**MECKLENBURG COUNTY
Land Use & Environmental Services Agency**

MEMORANDUM

Subject: Rezoning Petition Comments

2025-025: Legacy at Moss

SITE PLAN, RZP-2025-025

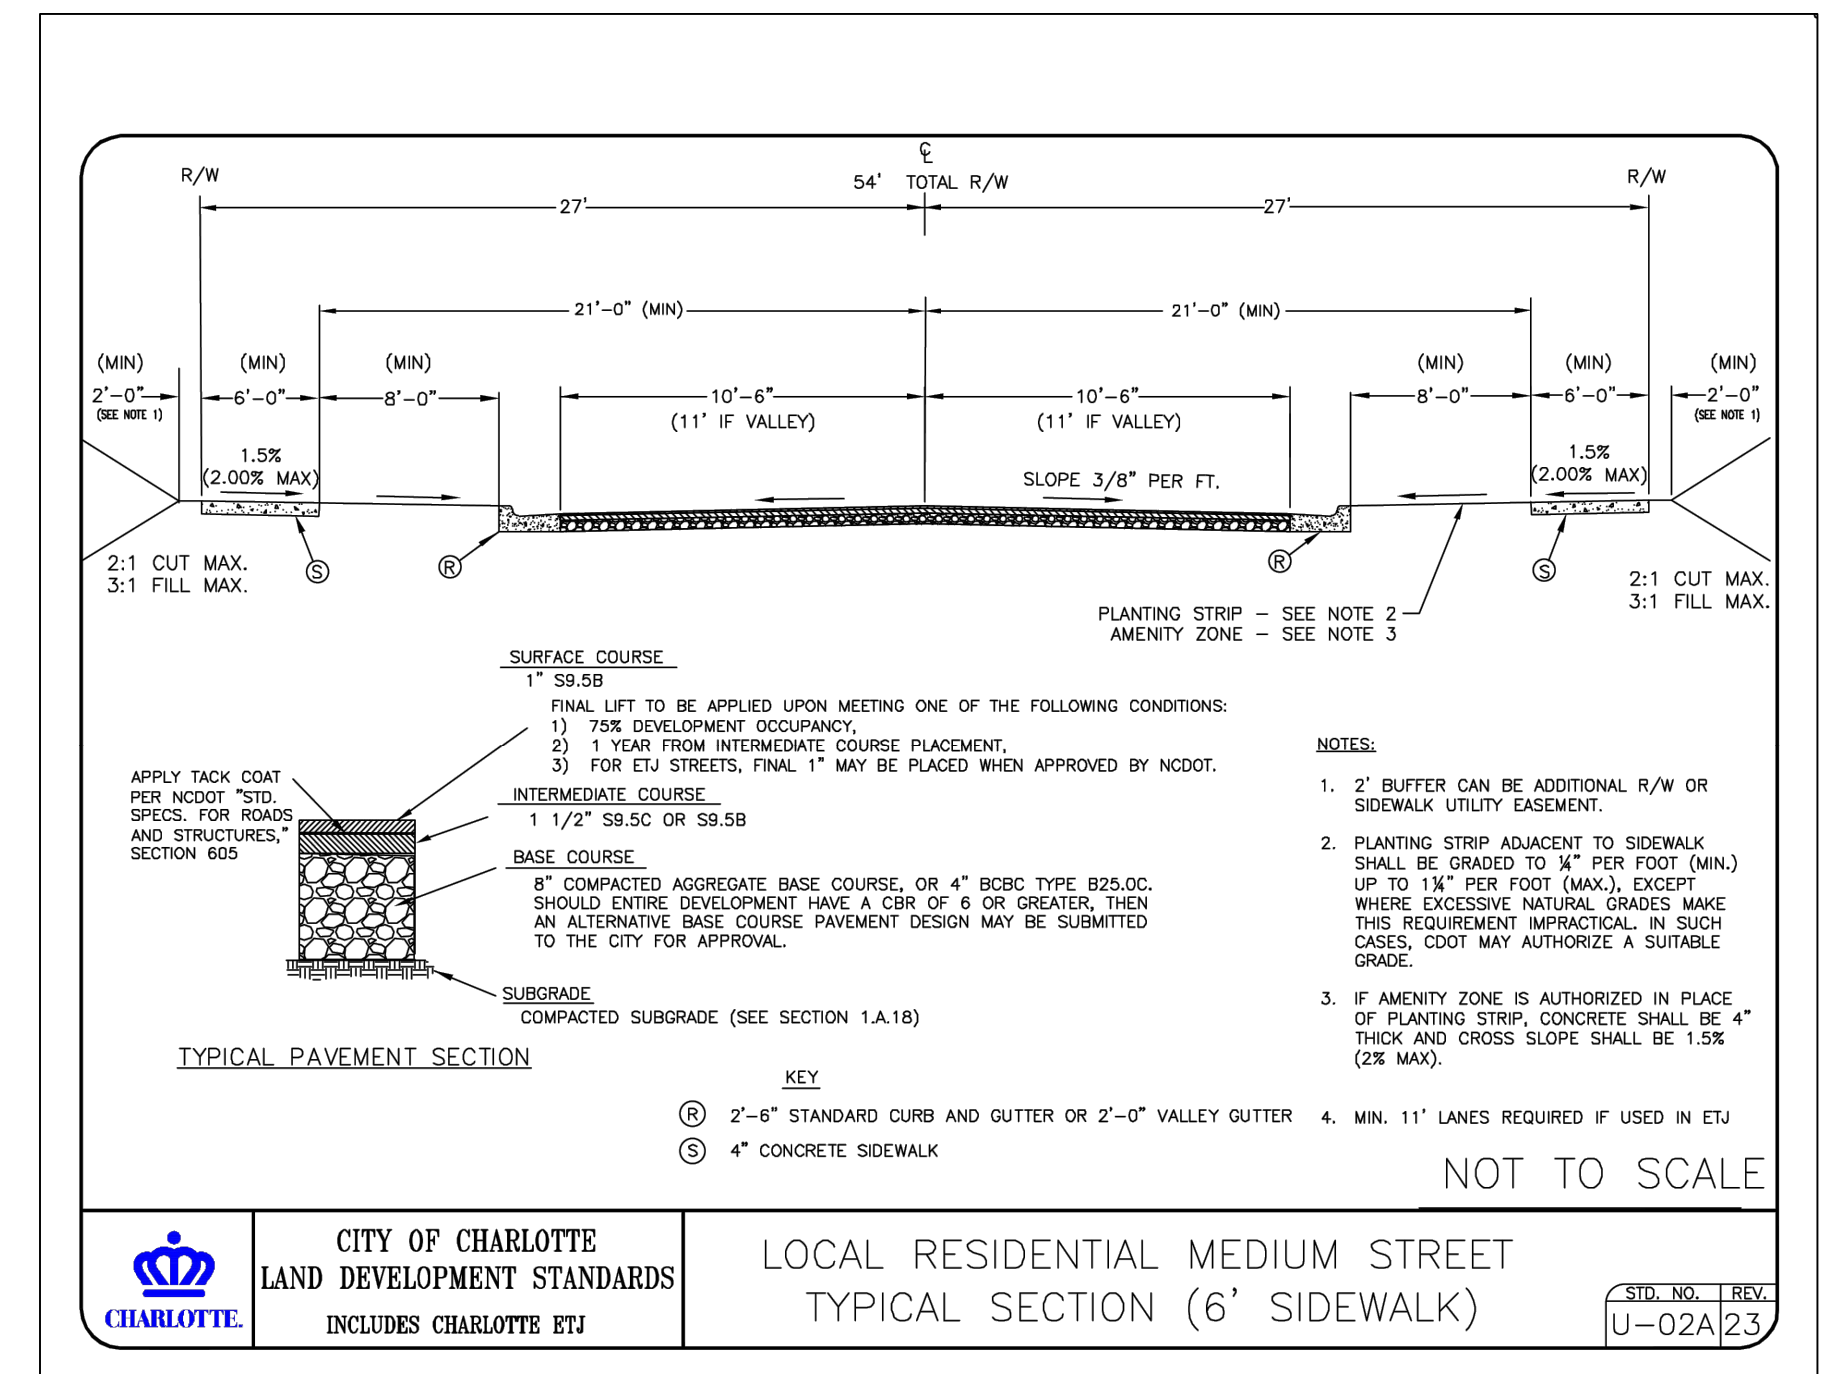
Storm Water Services Comments: The estimated SRRS score for this reach of Polk Ditch is 141. Based on the reach conditions, Stormwater Services would like to request a 50 foot, from top of bank, storm drain easement for a potential stream restoration project in the next 10 years.

A Floodplain Development Permit from the City of Charlotte is required for all proposed construction within the regulated floodplain. There are specific building requirements for any proposed structure located within the regulated floodplain. See City of Charlotte Unified Development Ordinance Article 27 for details.
